BCA ASSESSMENT REPORT

PROPOSED BRICKMAKING PLANT

416 BERRIMA ROAD, MOSS VALE

Revision 1

Figure 2: Site Plan

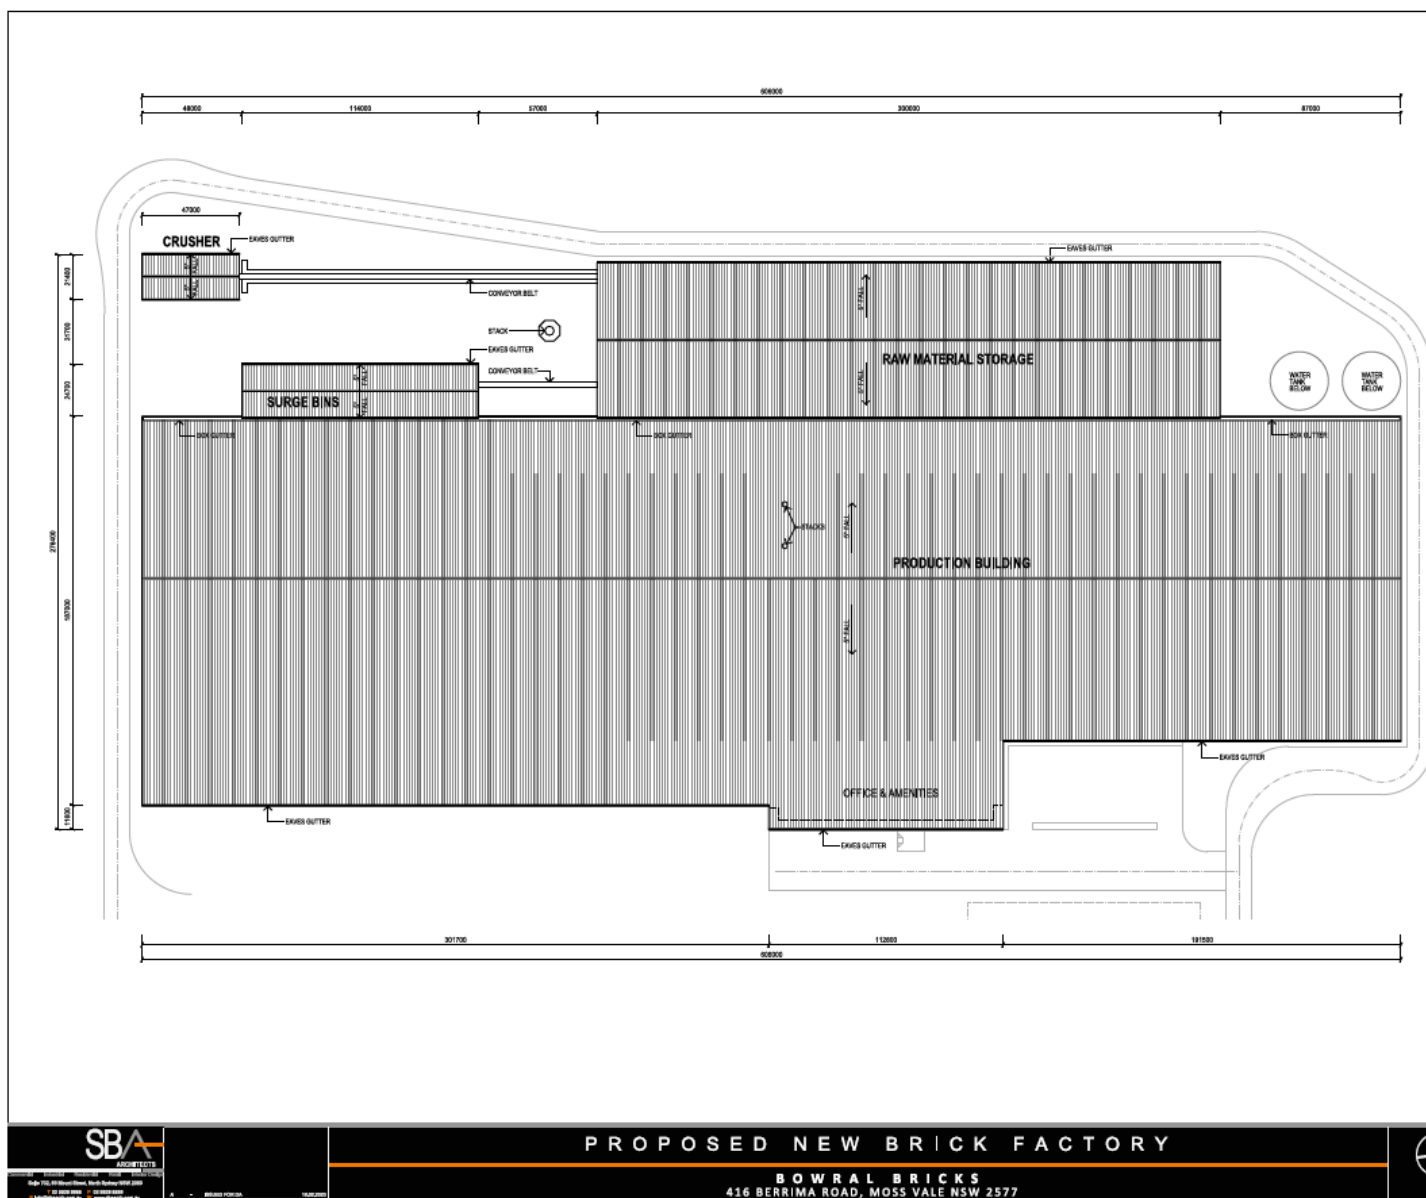
Comments: The proposed building complies with the provisions of C2.4 with the exception of the areas identified in blue in the following mark-up where the furthest part of the perimeter vehicular access path is greater than 18m from the external walls of the building:

In this regard, the above non-compliance is required to be addressed as a Performance Solution by the Fire Safety Engineer to demonstrate compliance with Performance Requirement CP9.

Comments: The exit travel distances in the building are considered to be non-compliant with the requirements of Clause D1.4 in the following areas:

Comments: The distances between alternative exits are considered non-compliant with the provisions of D1.5 in the following areas:
